From: Brenda Larsen
Sent: Friday, August 30, 2013 8:02 AM
To: Jeff Watson
Subject: RE: BL-13-00019 Brady

Re: Brady (BL-13-00019)

Brenda Larsen
Kittitas County Fire Marshal
509-962-7000

BOUNDARY LINE ADJUSTMENT
 PREPARED FOR
 MATT COE
 A PORTION OF THE EAST 1/2,
 SECTION 8, TOWNSHIP 18N., RANGE 19E., W.M.

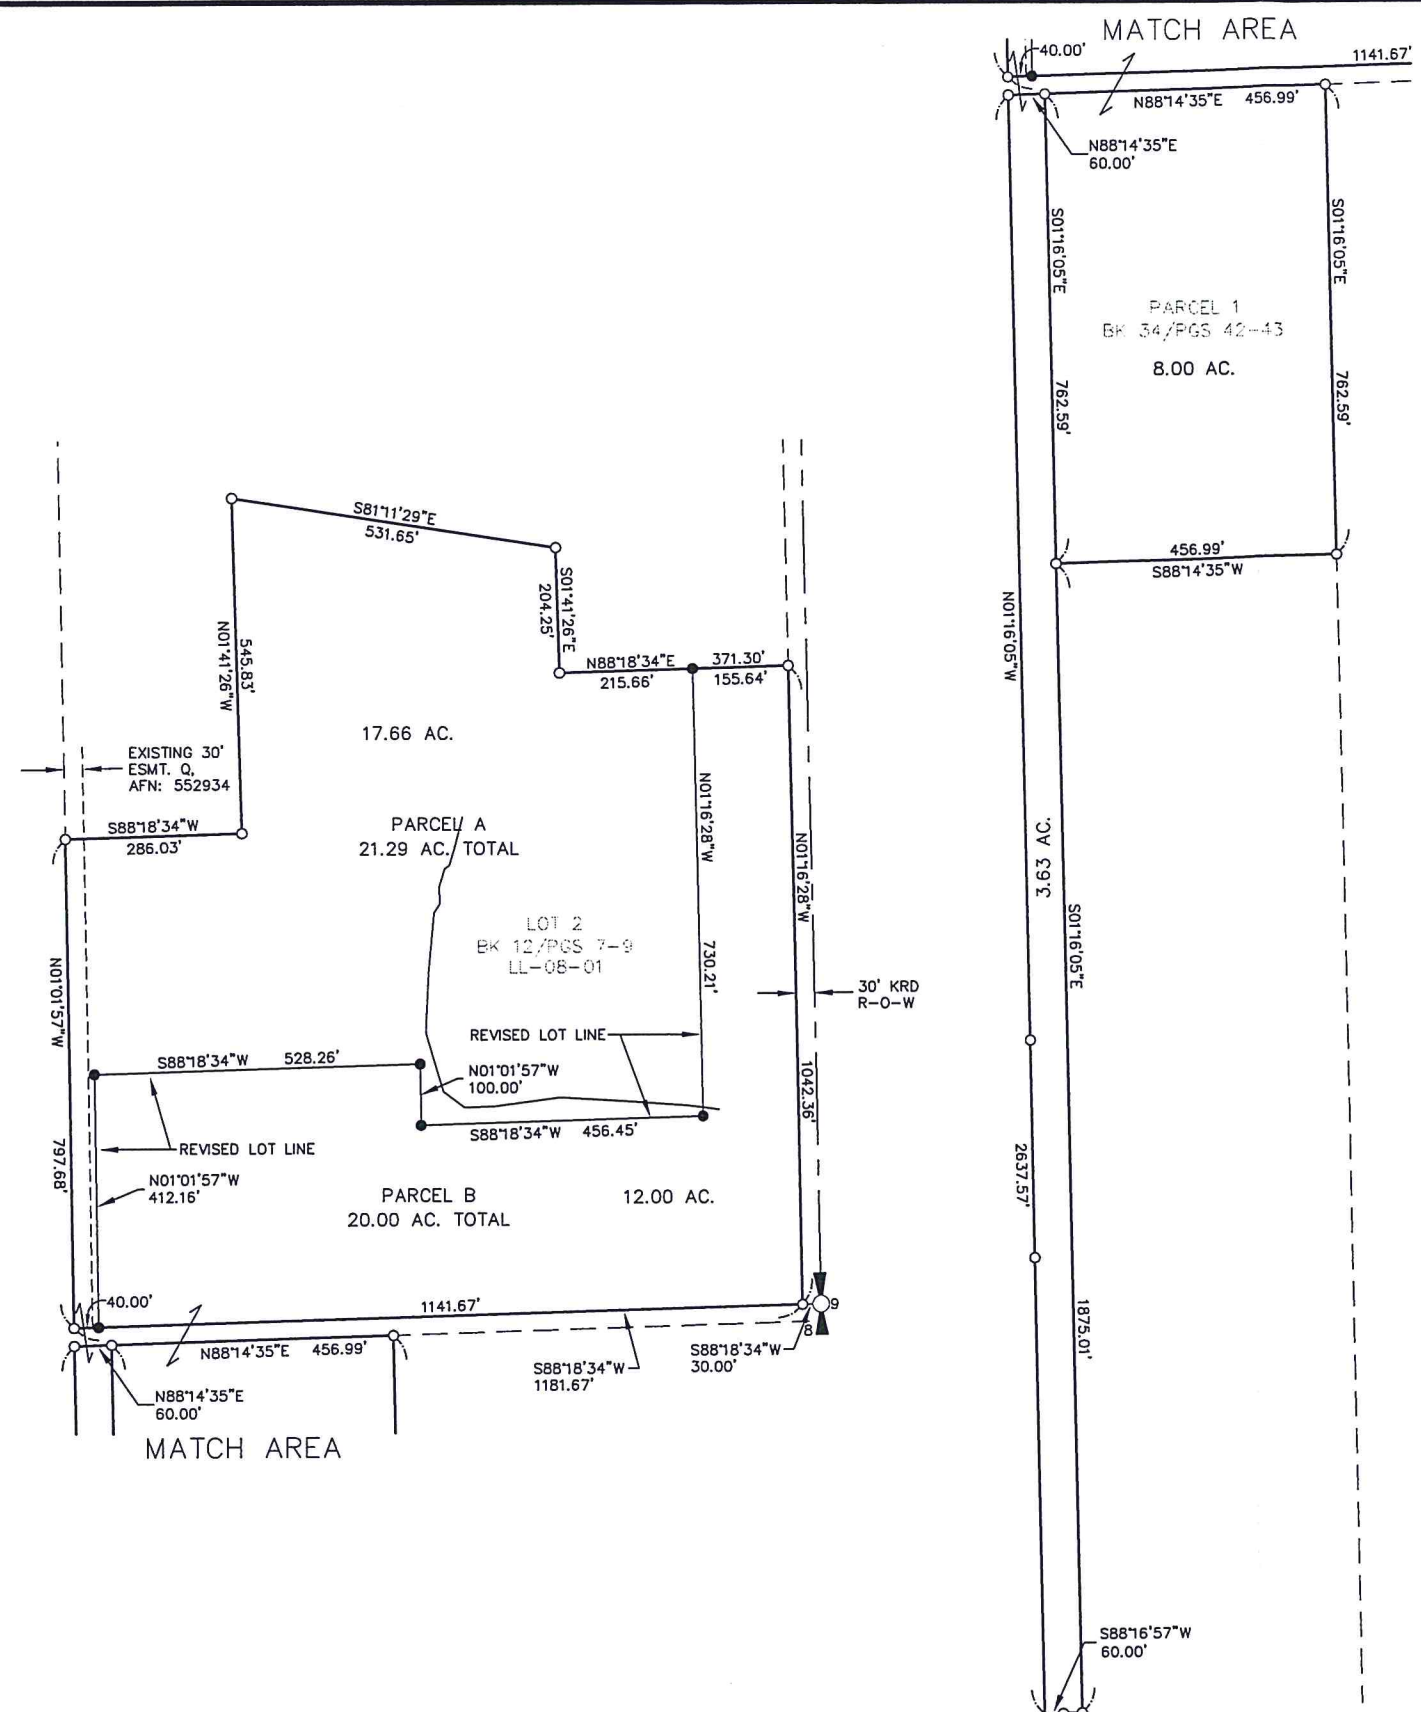
- Ensure that boundary line adjustments do not infringe upon existing structures, to include propane tanks, etc.
- Ensure adequate access for fire apparatus. Any driveways or access points created based off the new lot configurations shall comply with Kittitas County Code 20.02.030.
- All future development must comply with the International Fire Code.
